From: [Patrick Yamashita](#)
To: [Below, Matthew](#)
Subject: Mercer Island Transit Integration Project Completeness Review Status
Date: Wednesday, October 28, 2020 1:36:00 PM

COMPLETENESS REVIEW

The Sound Transit permit applications for the Mercer Island Transit Integration Project (the "Project") have been reviewed for completeness.

DRAWING No.: E07-LPN001
LOCATION ID: E07
SHEET No.: 94 OF 104 REV: 0

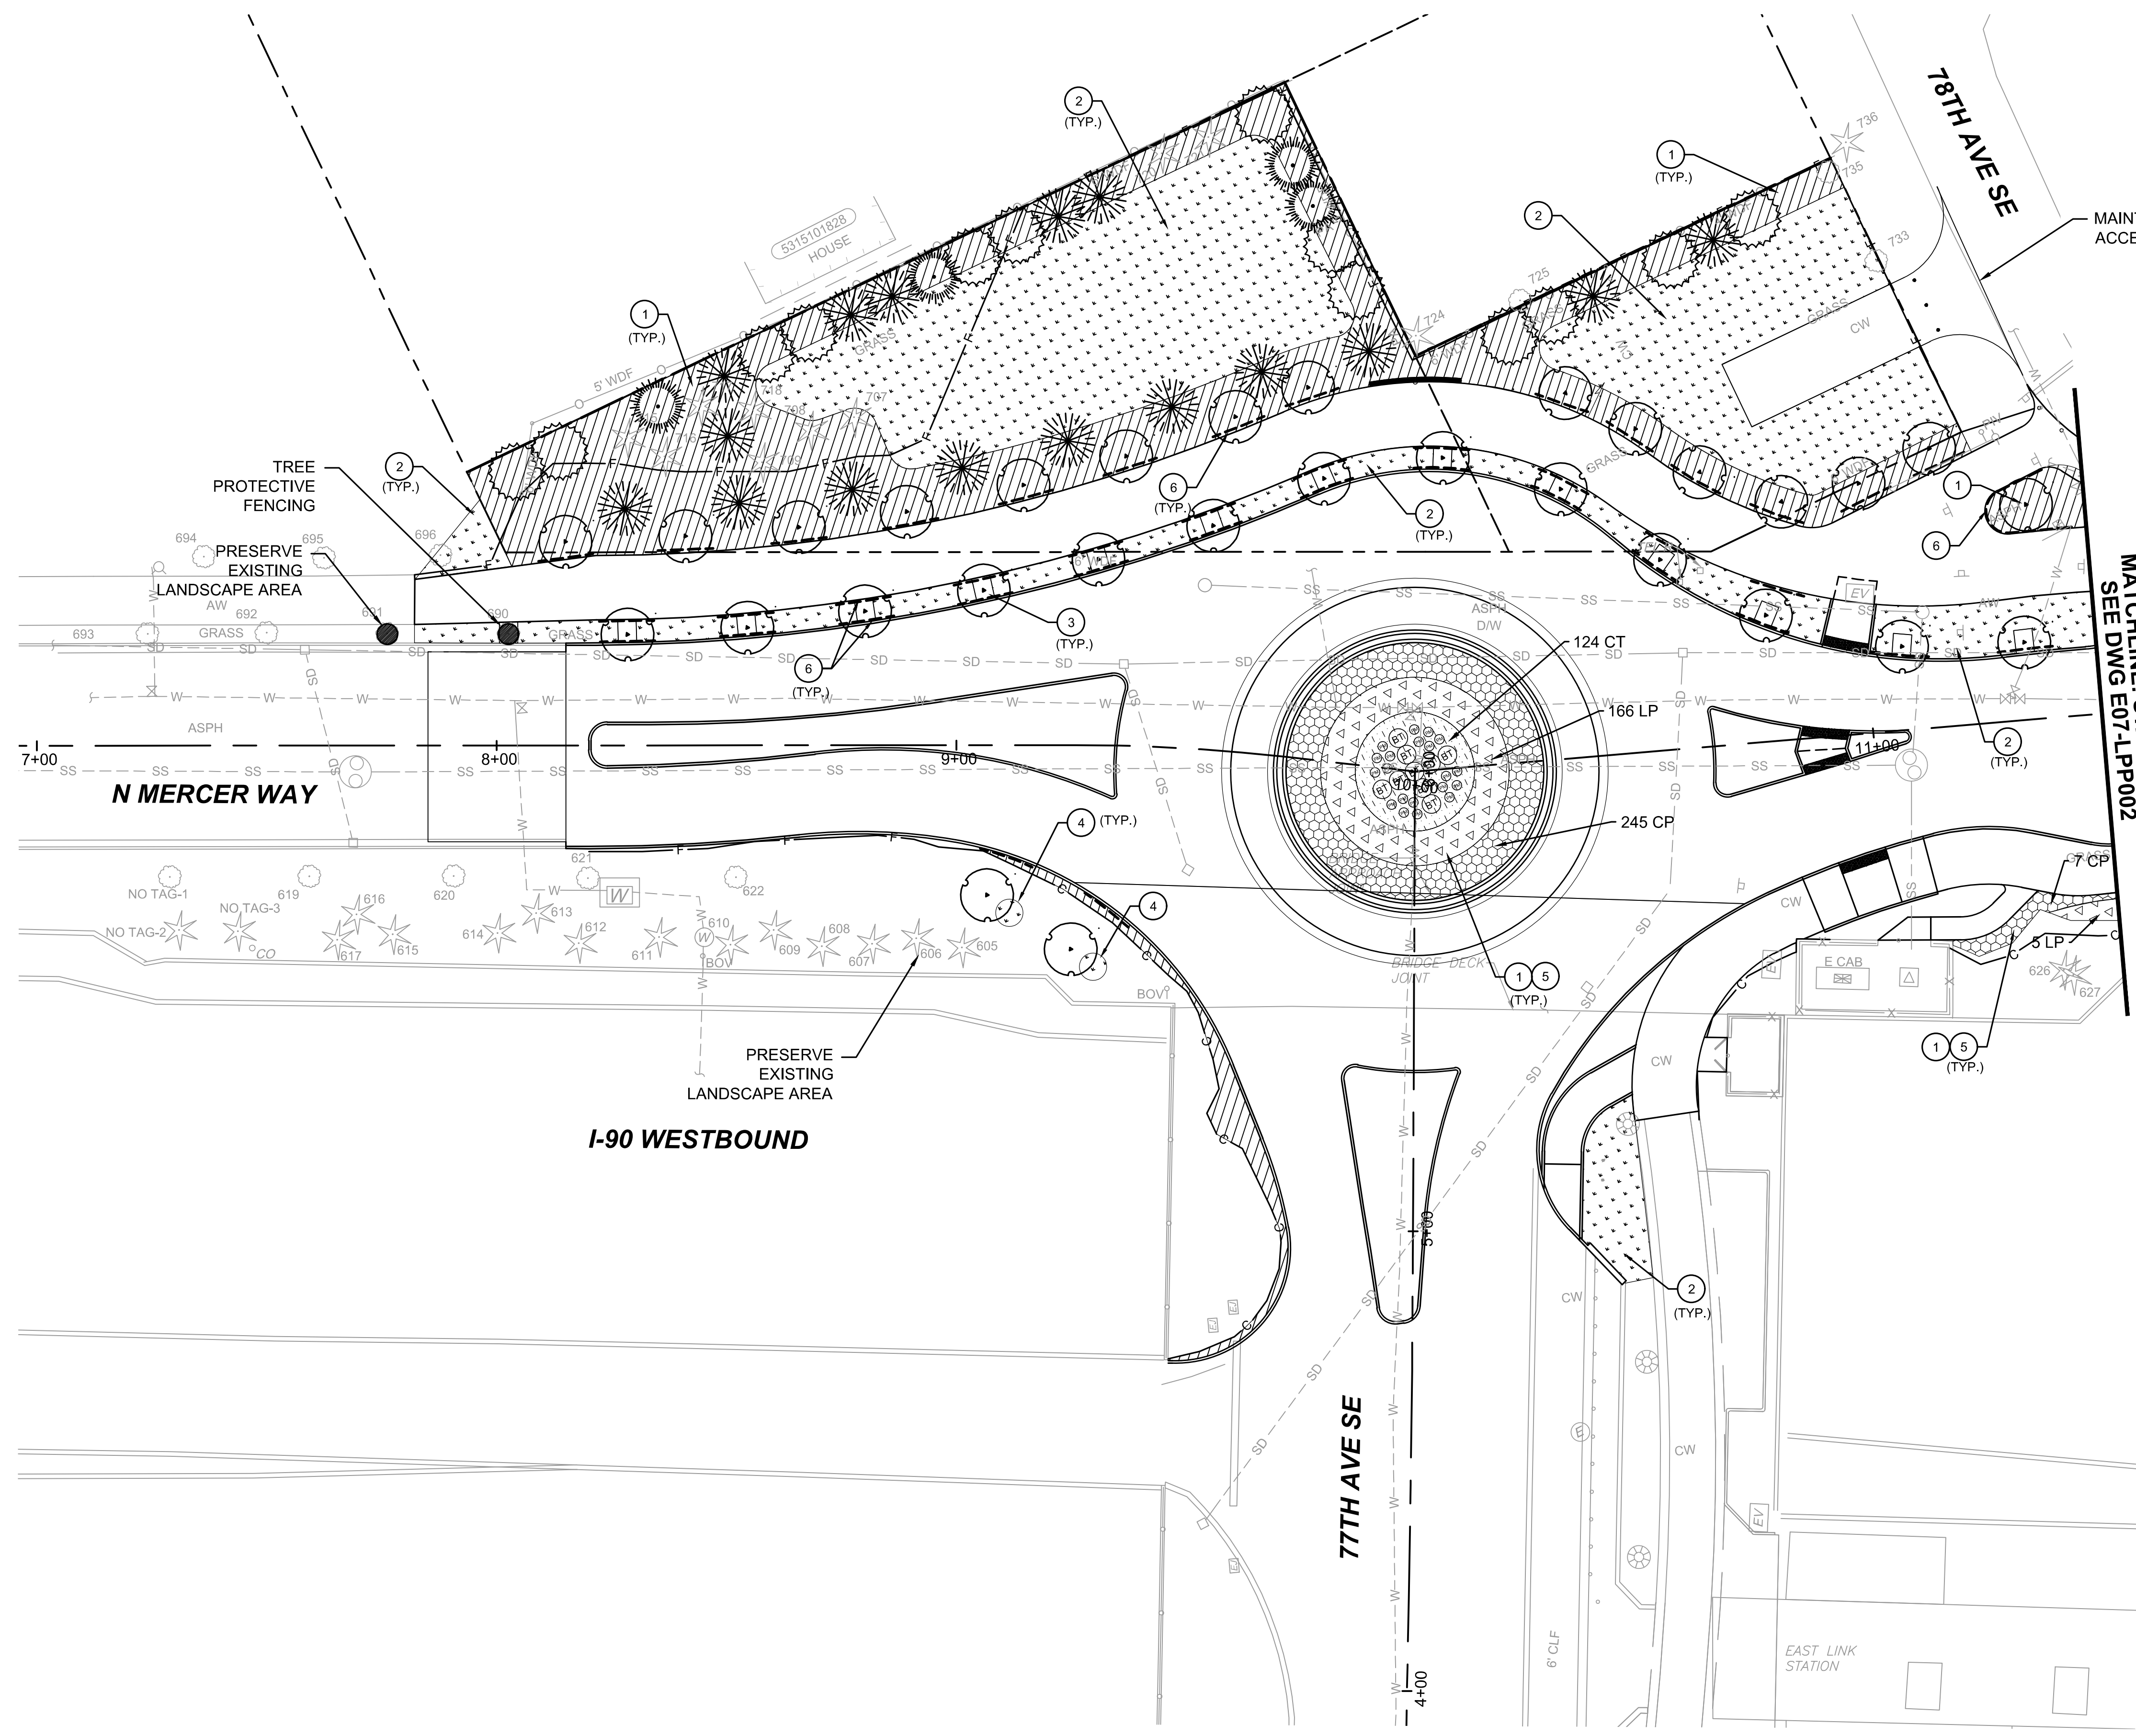
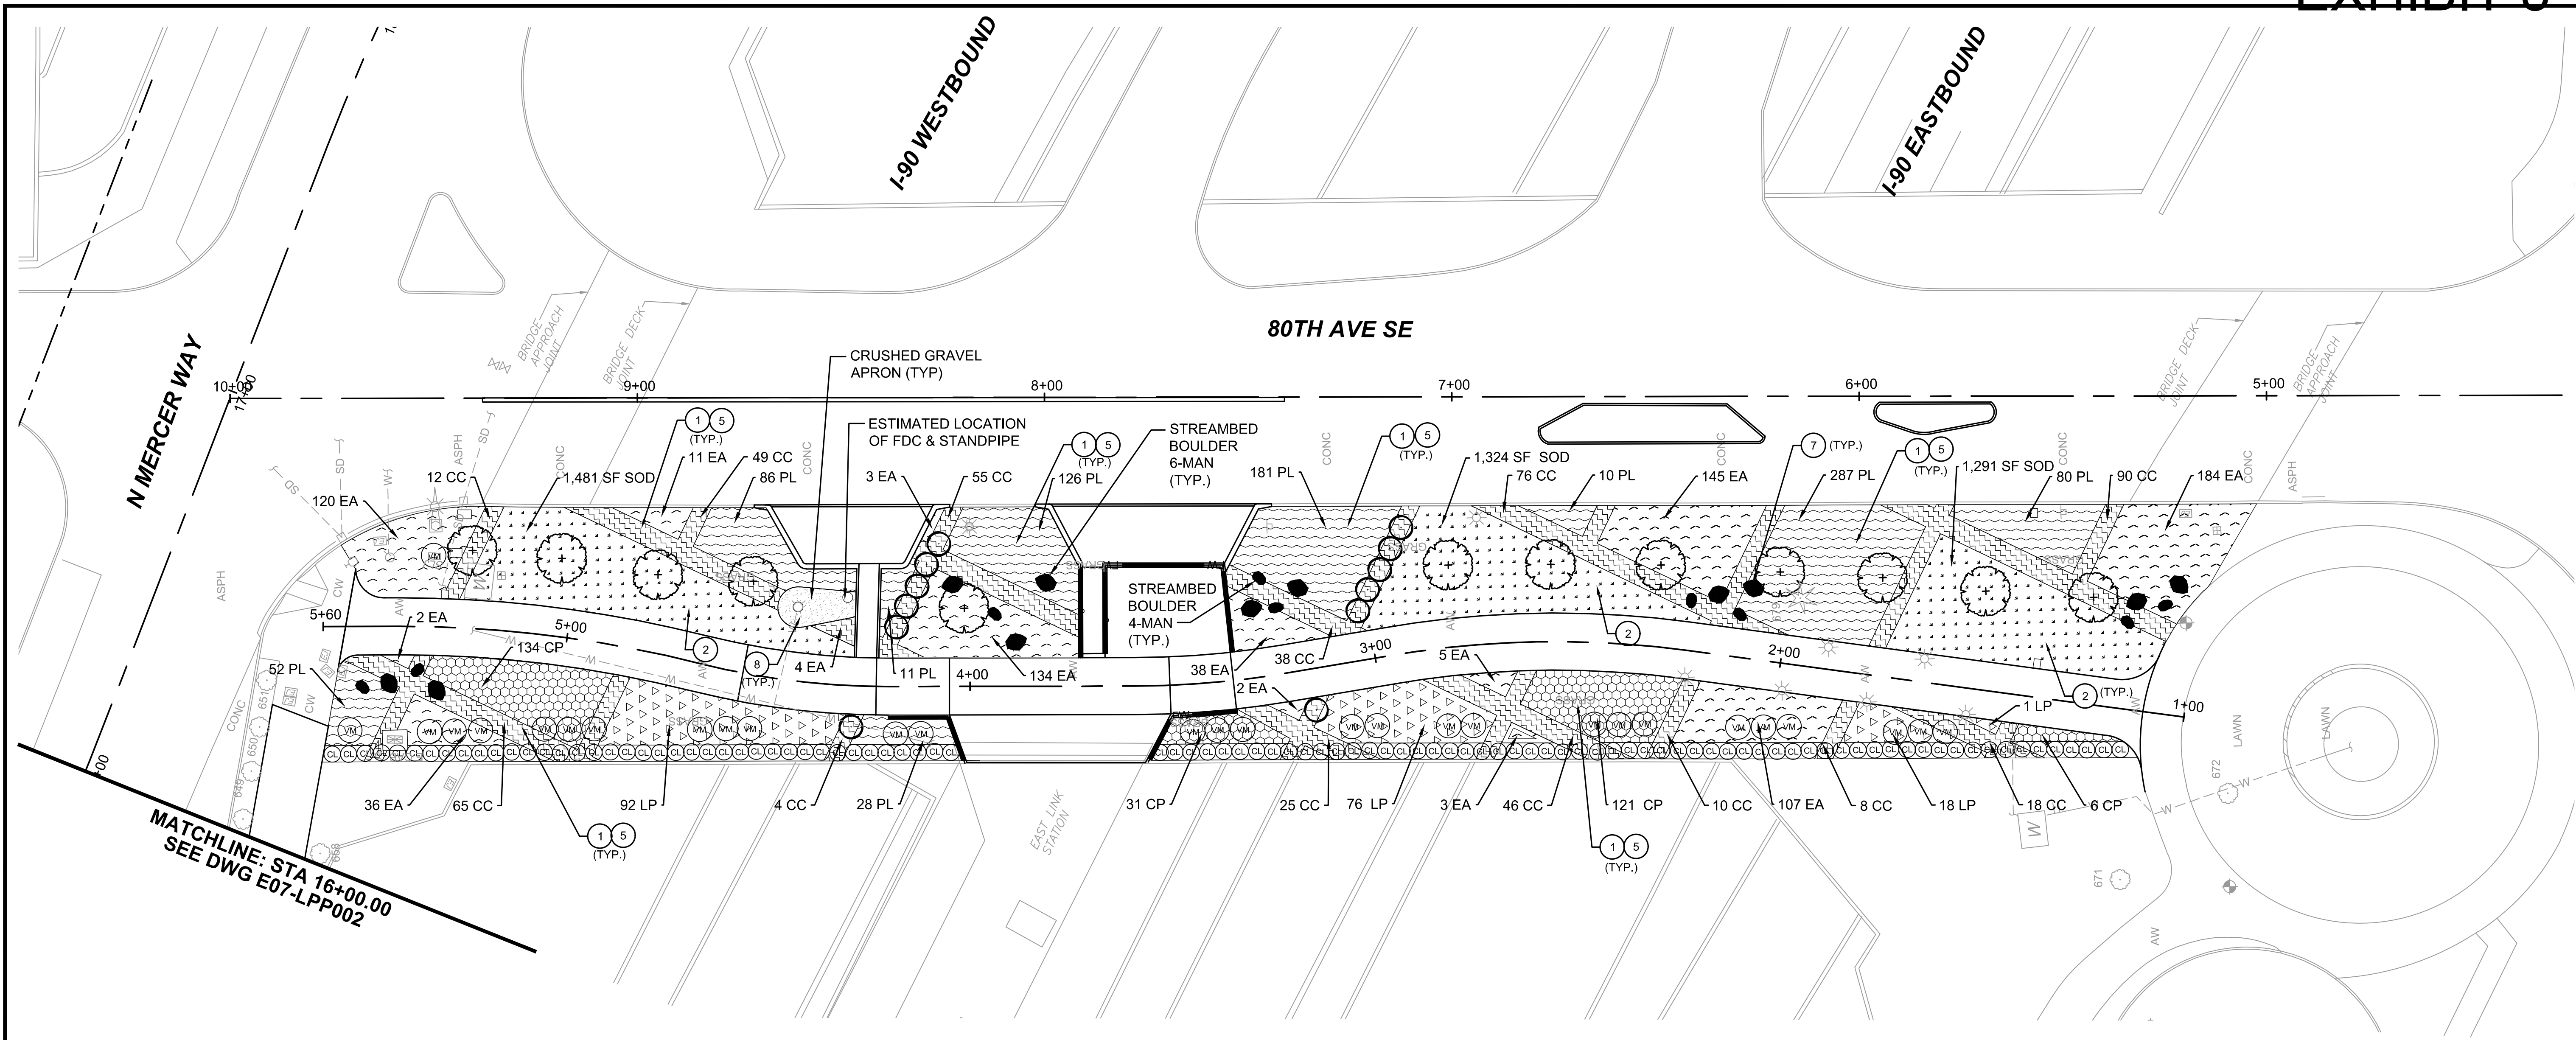
ROW use permit: CPD17 & CPD18 indicated not to plant large trees in roundabout near/over underground utilities and to show underground utilities on the landscape plans to help identify whether there may be conflicts between utilities and landscape improvements. ST responded by adjusting from multiple trees to one tree stating that it would be away from utilities and that landscaping was previously coordinated with CMI fire department. Coordination must also be with Public Works engineering who reviews water, sewer, and stormwater system impacts. Please note that the proposed tree is located directly on top of the City's sewer main and water main, hence the reason for the request to show utilities (water, sewer, storm). This is not an acceptable location for the tree. Show utilities and adjust tree location. Please contact the Senior Development Review Engineer (ruji.ding@mercergov.org) and we can work together on determining a

better tree location.
